Our Ref: WS010005

### **Application by Augean South Limited for an Order Granting Development Consent for the East Northants Resource Management Facility Western Extension**

#### **Request for Further Information**

#### ***Proposed Change and Western Power Distribution (WPD)***

Figure ESA5.1 Scale: 1:2,500@A2

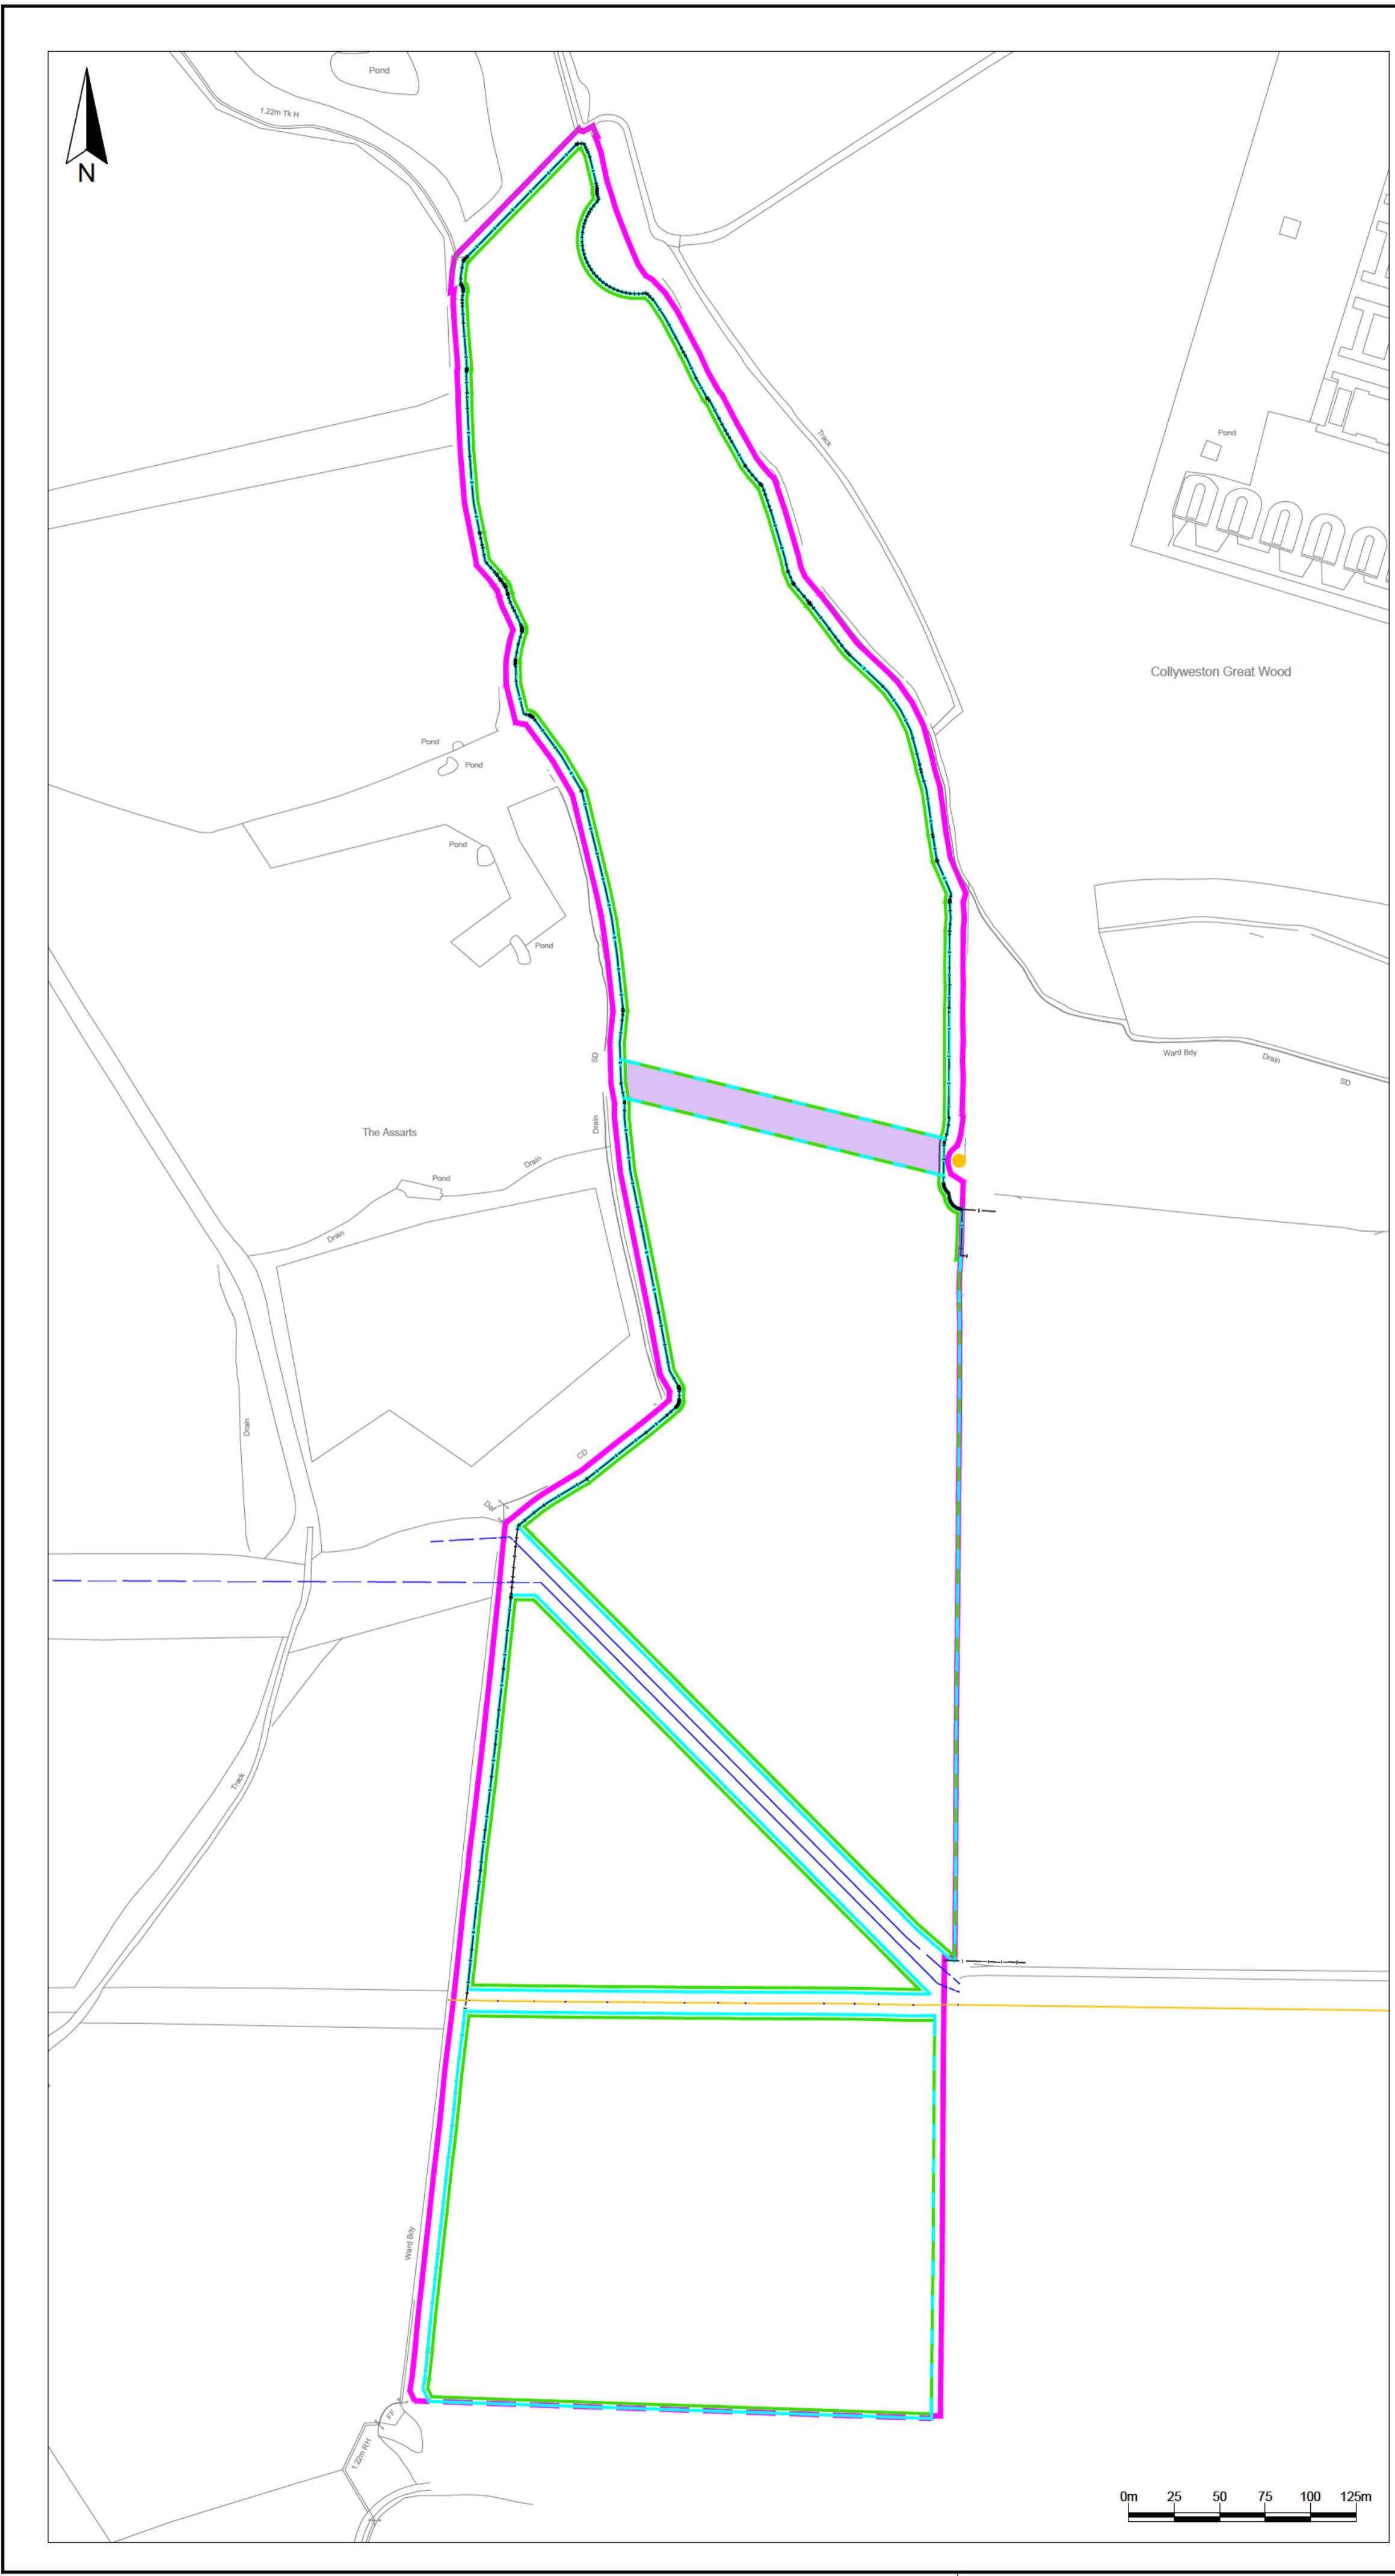
I write following the Applicant's request for a proposed change to the Application and its Deadline 7 submissions. Together, those submissions establish a 20m stand-off distance for the Anglian Water (AW) pipelines which cross the western extension land. The Proposed Development also includes the diversion of an overhead electricity cable to follow broadly the same route as the water pipelines (Work 5). However, it is not clear from the Applicant's recent submissions what distance the electricity cable would be from the pipelines. The matter is referred to in the Deadline 7 versions of the DEC Appendix B and the draft Statement of Common Ground (with WPD), as well as the later emails in the bundle of correspondence with AW. The submissions suggest that the matter would be controlled through the Protective Provisions for WPD. Again however, the Provisions as currently drafted do not specify a stand-off distance or other parameter.

I should be grateful if the Applicant would clarify its proposal for the separation distance between the electricity cable and the water pipelines and how this would be controlled through the DCO. It would also help the Examination to have the views of WPD and AW on this matter.
